Application for a non-material amendment following a grant of planning permission.

PROPOSED REAR EXTENSION

H02-0009-15

1 3D View 1

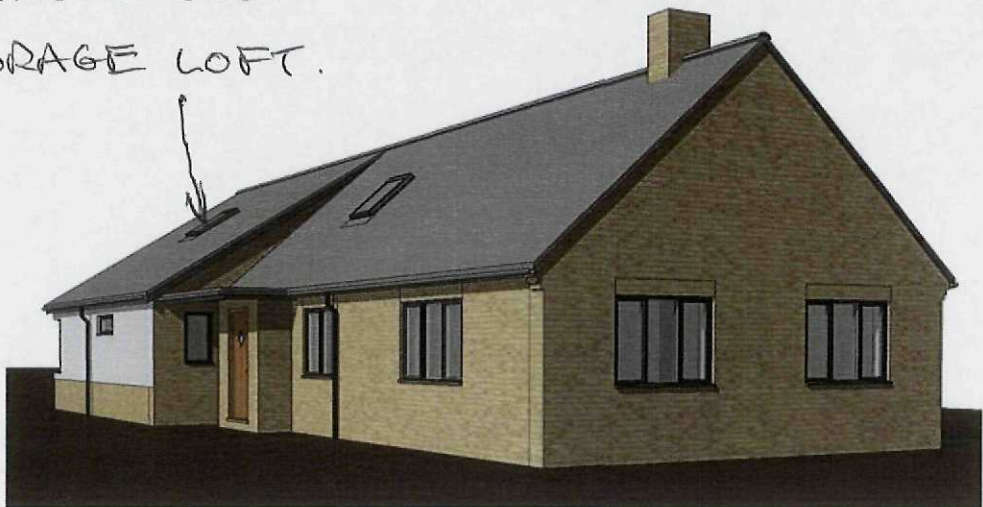
ALSO, DELETE VELUX-TYPE WINDOW OVER STORAGE LOFT.

3 3D View 3

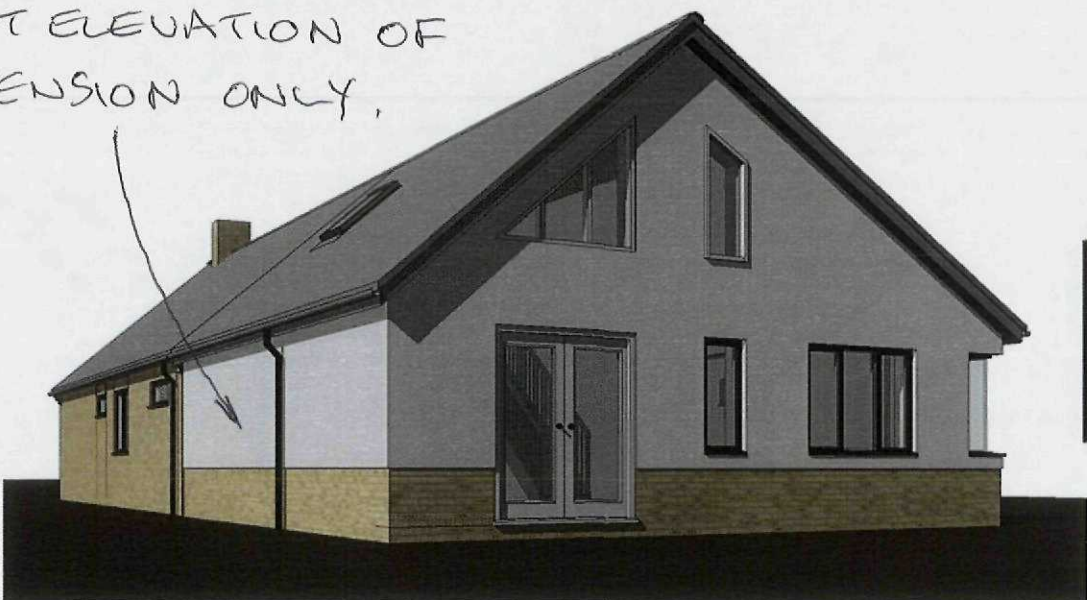
REPLACE PROPOSED RENDER ON WEST ELEVATION OF EXTENSION WITH BRICK, MATCHING OTHER BRICKWORK USED IN OTHER PARTS OF EXTENSION.
